From: Jacky Homer [mailto:]
Sent: 20 October 2015 12:45
To: Nicholas Coombes
Subject: Brampton NMU crossing

Re HE's Deadline 11 comments on my Deadline 10 submission:
2.16 Jacky Homer

Drawing title: **LAND PLANS REGULATION 5(2)(i) SHEET 8 OF 40**

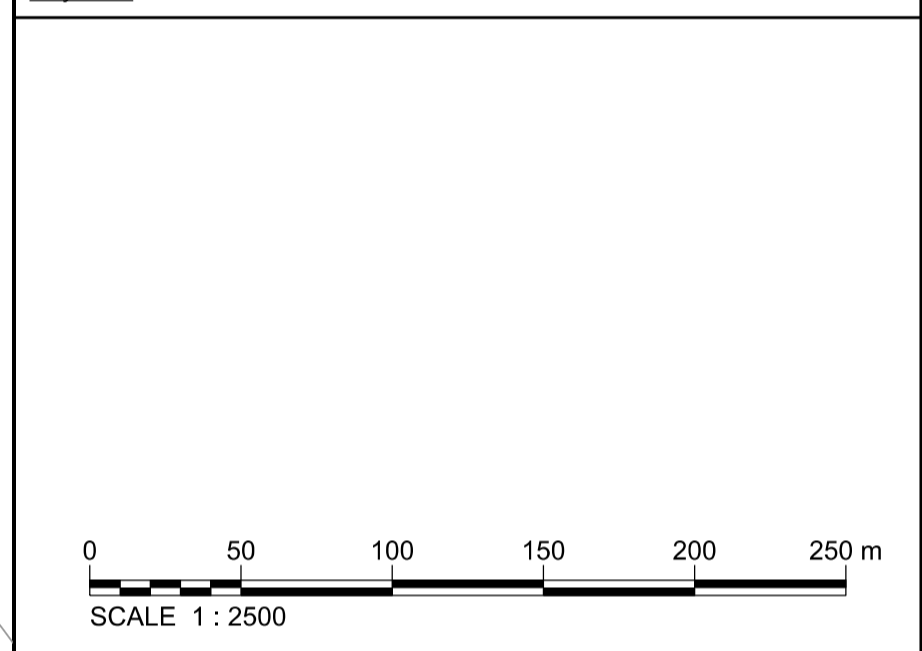
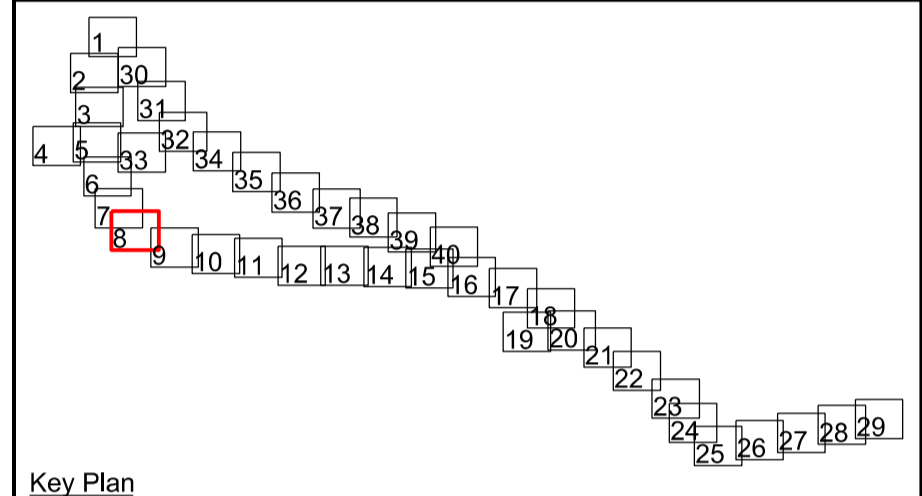
1. Noted - but I thought this was the detailed design process.
2. I do not agree that the new NMU crossing would be perceived as more convenient to those people from the Law's Crescent area who currently use the unofficial crossing across the slip road which, it appears, will still exist. I think a visit to the site by HE to compare the two access points would confirm that the unofficial one needs to be blocked for reasons of safety.
3. Noted. However, the lack of a convenient path makes the above point more important
